Historic England

**STONYHURST COLLEGE, AVENUE ROAD, HURST GREEN, LANCASHIRE, BB7
9PZ**

Application No. 3/2017/160 & 3/2017/0161

Stonyhurst College
Proposed Access Plan & Long Section

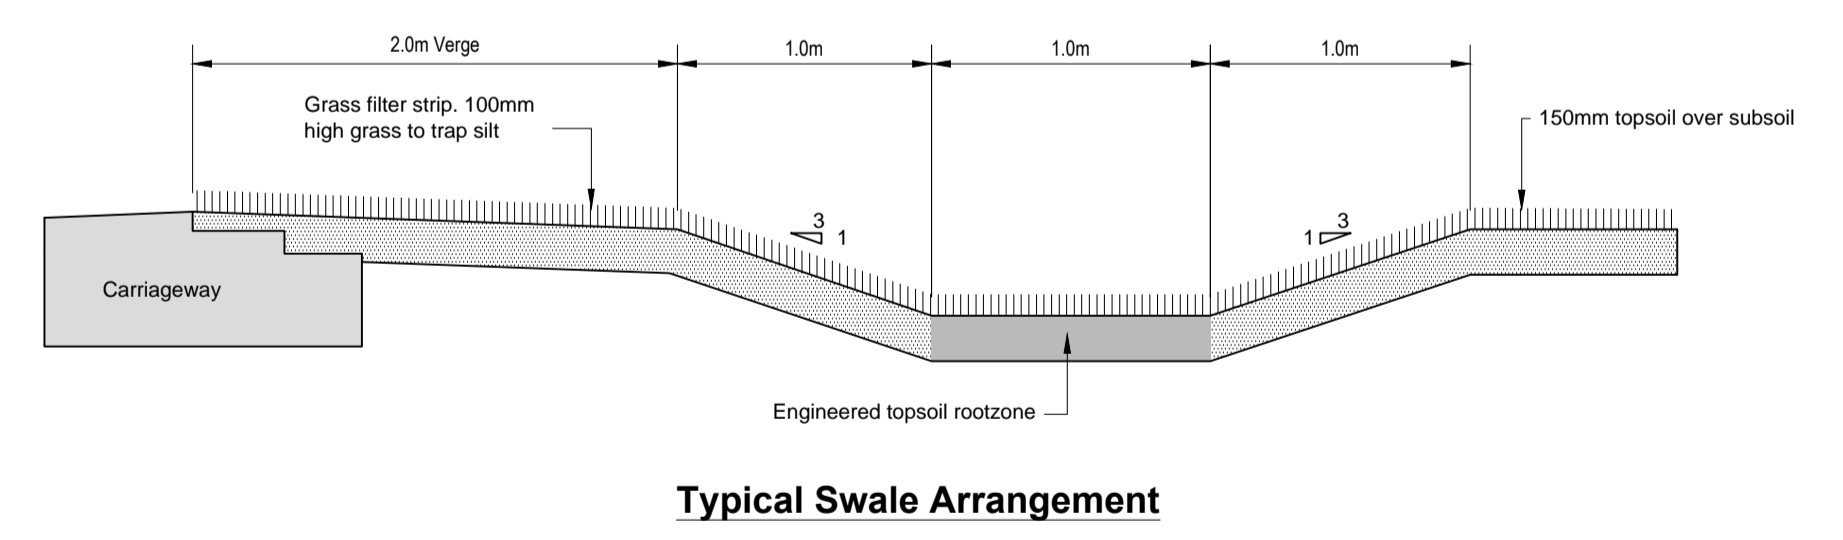
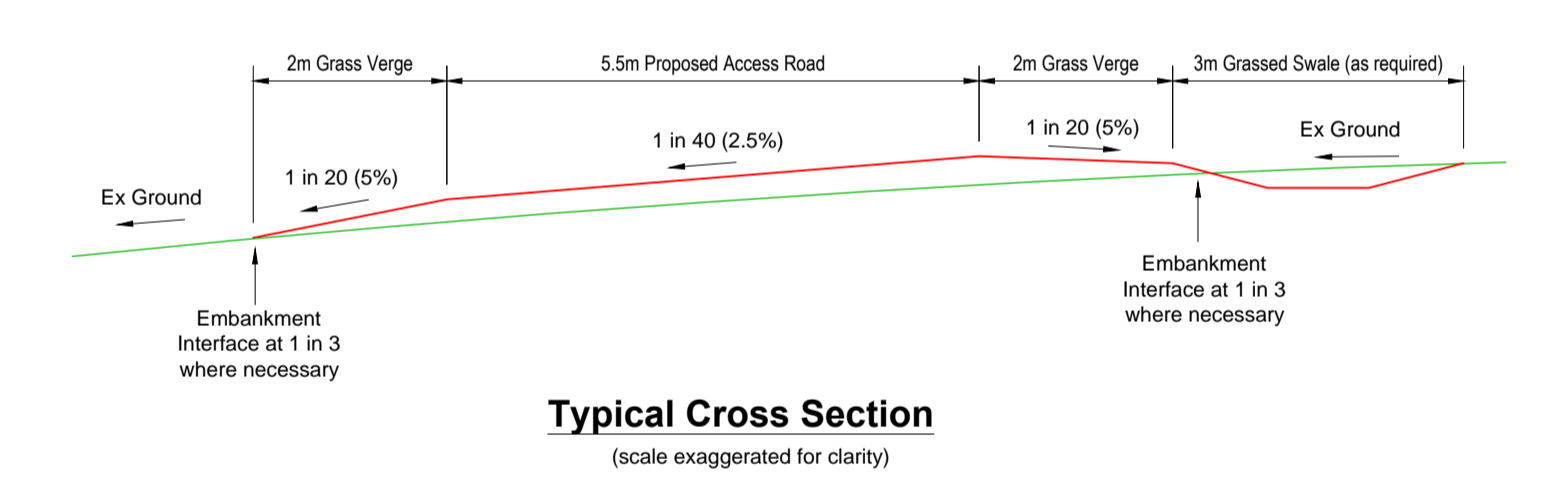
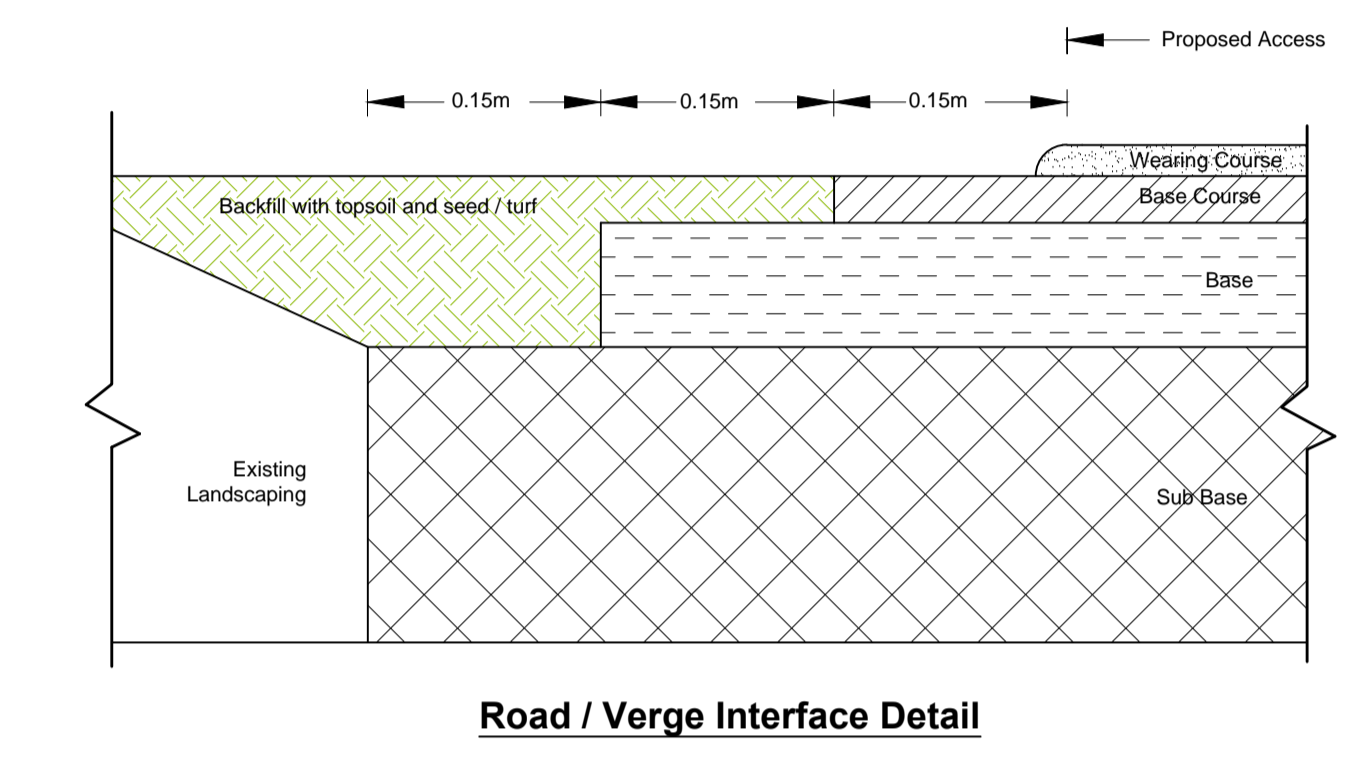
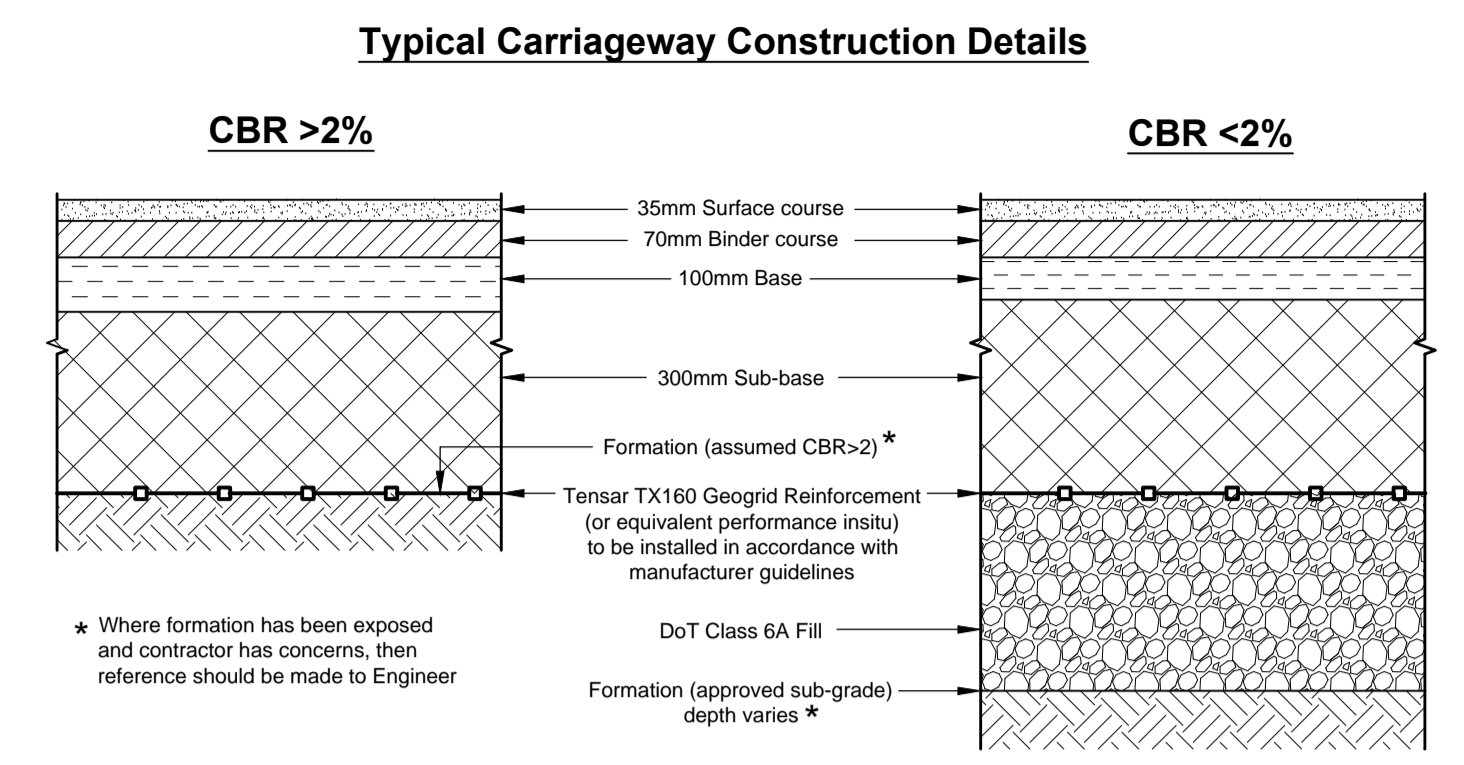
Consideration needs to be given to the detailed highway engineering of the road as in order to achieve the symmetry which the scheme hopes to deliver, a sensitive touch will be needed for the design of the road itself.
